Engineers Comments Regarding Surface Water Drainage

Application Reference:	WA/79/26/DOC	Reviewer Reference:	ADC/EXT5/AF
Planning Officer:	Amber Willard	Date of Review:	1/10/2026
Site Name:	Stoneybrook Farm Eastergate Lane Walberton BN18 0BA		
Application Description:	Approval of details reserved by condition under WA/108/24/PL relating to condition 3- Surface Water Drainage.		
Assessment Number:	1

Application Reference: WA/79/26/DOC Site Name: Stoneybrook Farm Eastergate Lane Walberton BN18 0BA	Initial Issue Date: 07/09/2026 Issue Date: 1/10/2026 Reviewer Reference: ADC/EXT5/AF
---	--

Section - Headwall Gabion Cage Filter (Outlet)

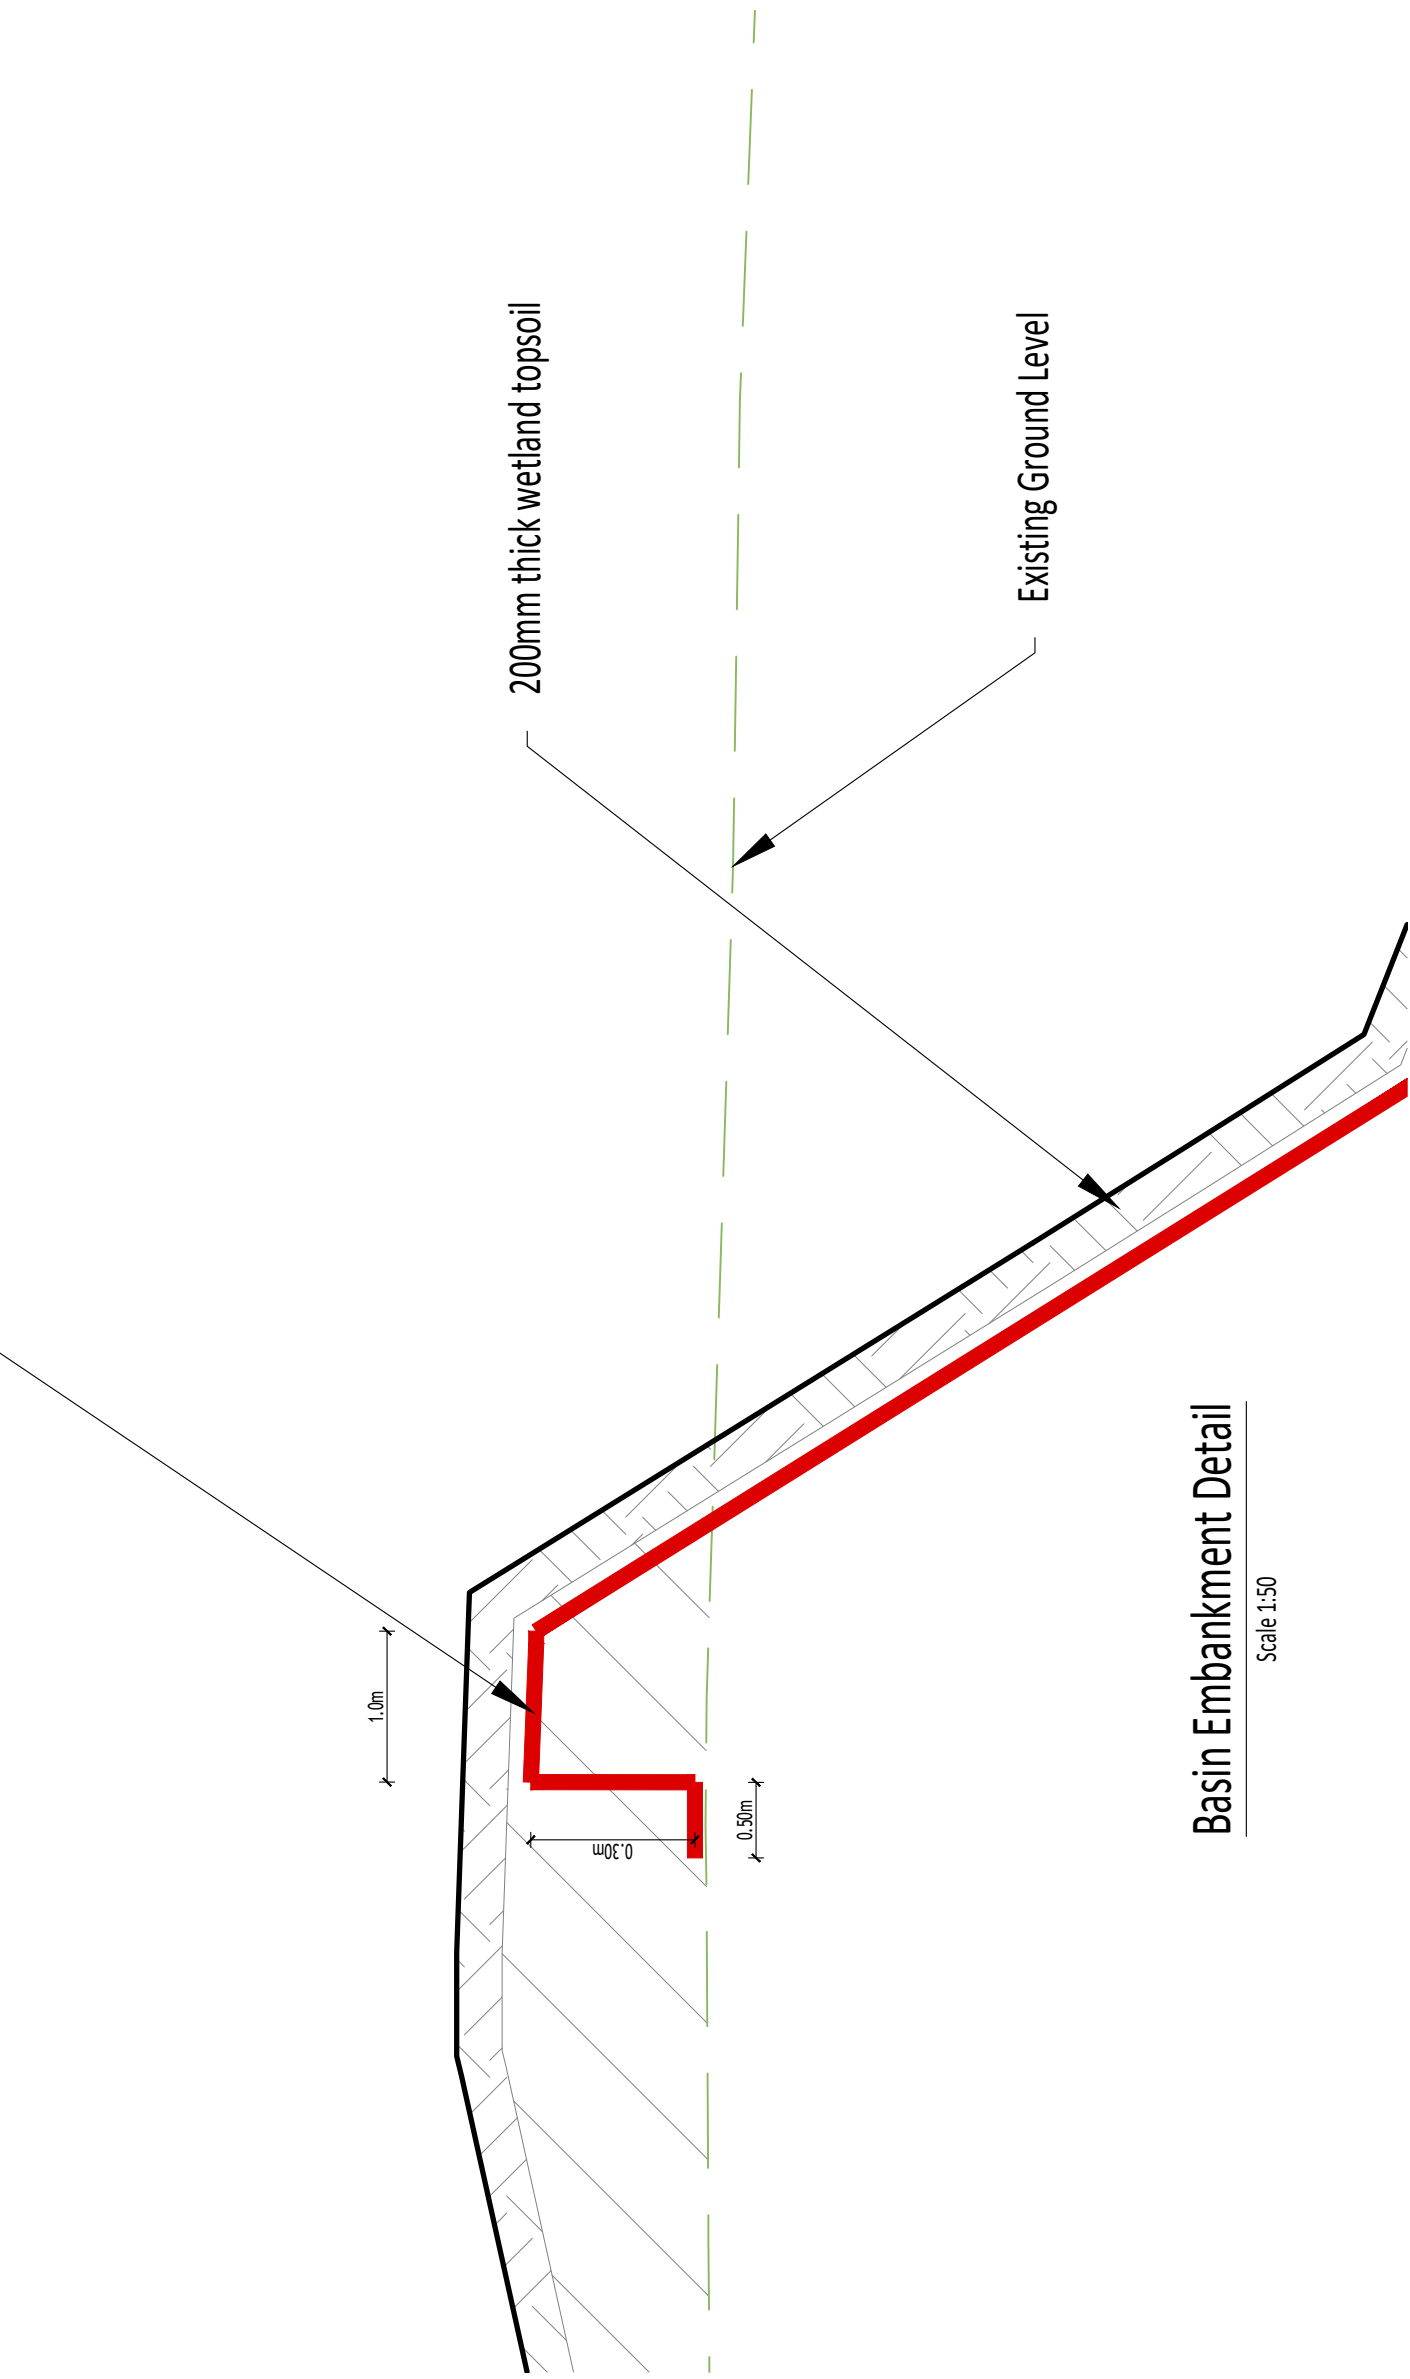
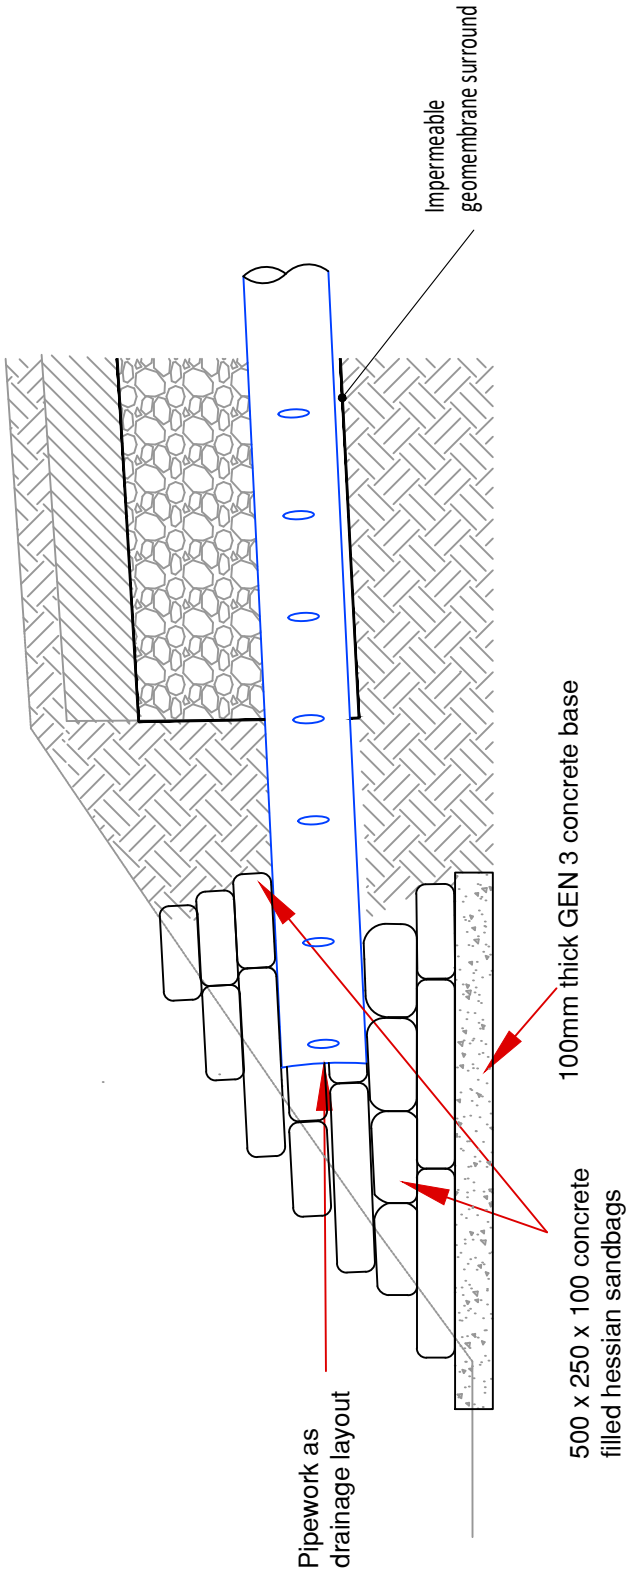
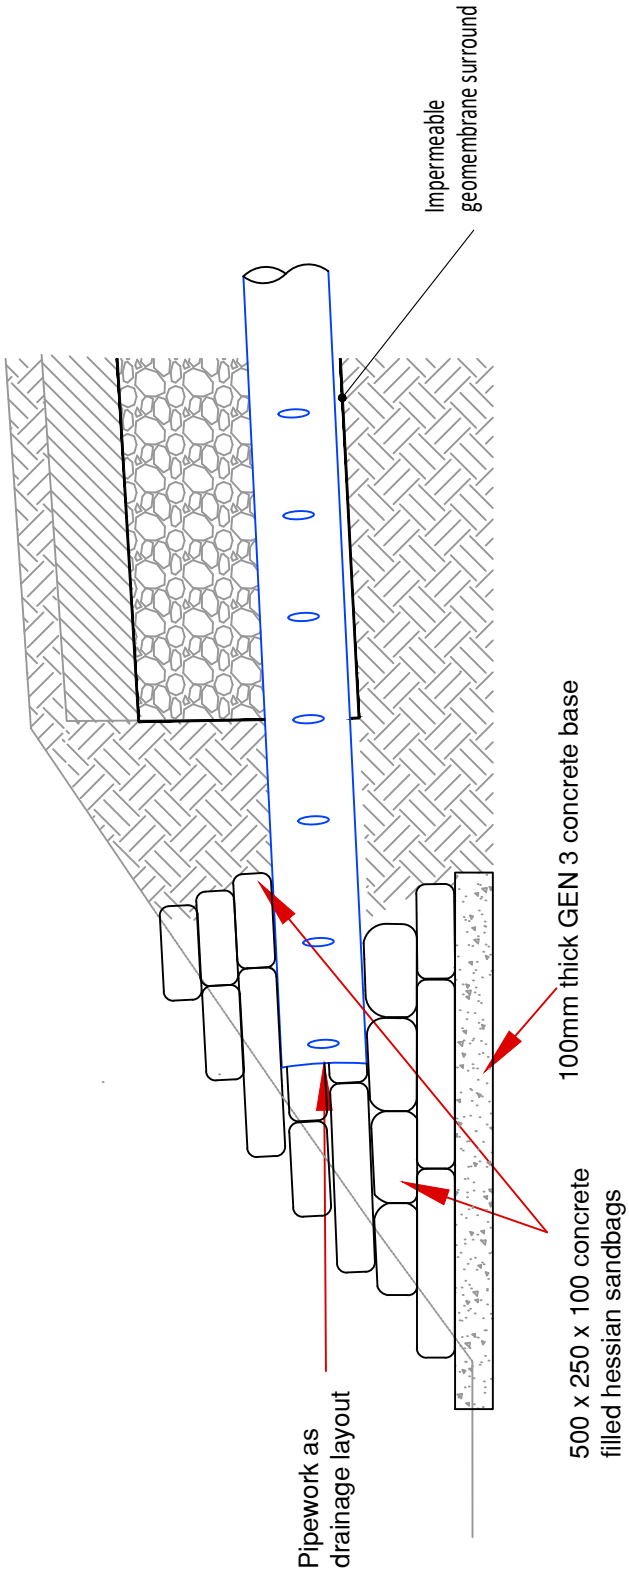
7.	Measures to mitigate blockage of the flow control device should be incorporated at the basin headwall and flow control chamber. Designer Response 03/06/2026 Gabion cage is proposed in front of the outlet headwall to provide a filter process and remove debris that could cause blockages. Construction detail provided.	The gabion inlet provides suitable blockage reduction from the open feature. Details should be provided for the flow control chamber to include blockage protection.	Contraflow chamber specified with upstream filter guard	The solution is acceptable, however, this is not reflected on Construction Details drawing A001-013/302.	The drawings have been revised and are acceptable.
